**CITY OF ALBUQUERQUE
PLANNING DEPARTMENT
May 1, 2013
DRB Comments**

PROJECT # 1009506

APPLICATION # 13-70⁷⁰⁵²²~~486~~

RE: Tracts 14-18, 20 & 21, Volcano Cliffs Unit 6

# SITE DEVELOPMENT PLAN FOR SUBDIVISION MONTECITO WEST UNIT 1

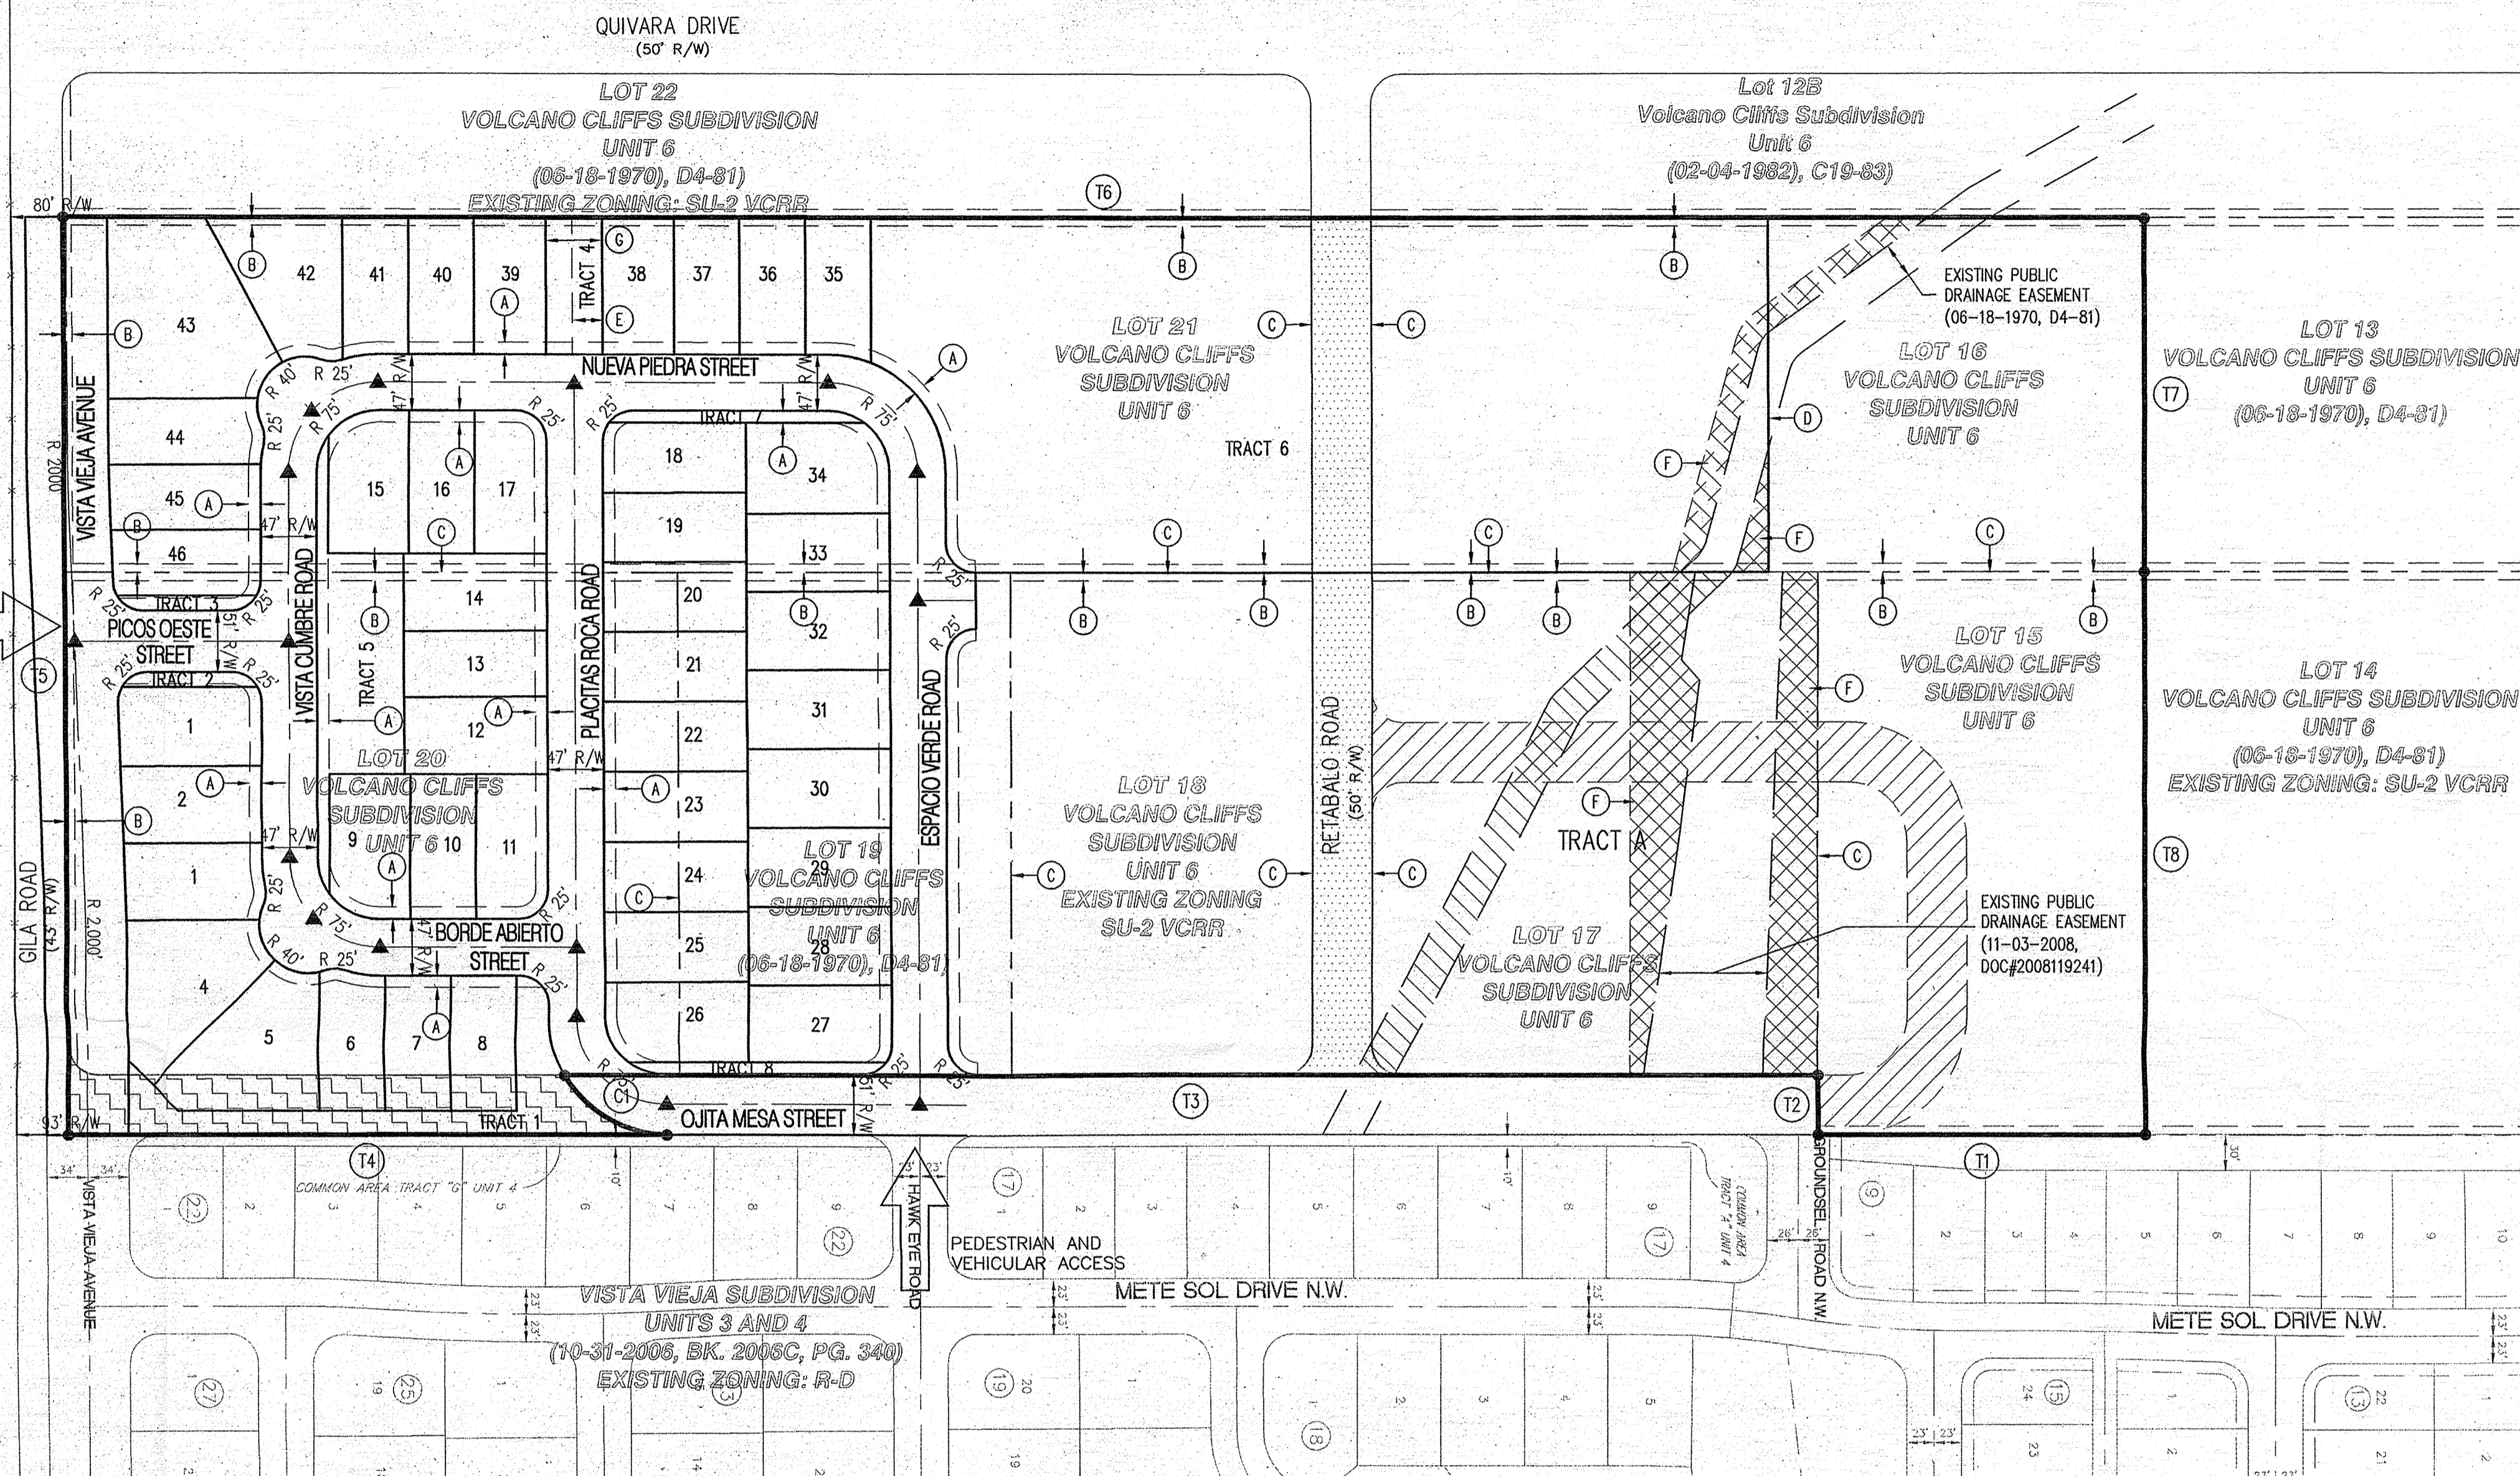
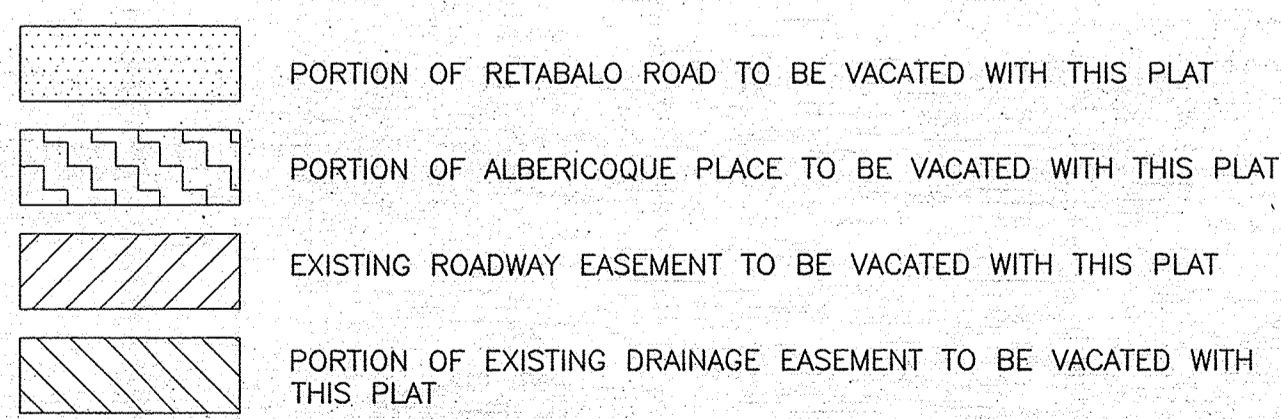
Refer to Section 14-16-3-16 of the Zoning Code for requirements of a Private Commons Development. Proposed subdivision would require the participation of Tract 1 on the north side; rather than vacating the whole frontage, it appears the proposed 25 feet of vacated ROW could be made up by narrowing the adjoining blocks without reducing the number of proposed lots. Villa Real could then connect to proposed interior north/ south street.

Rather than having a stub street to Tract 22 in the southwest corner of the site (which appears will have adequate access on Quivira), connectivity could be by flipping that street further north and to the east as an extension to Tract 19, and provide an eyebrow in lieu of the cul de sac.
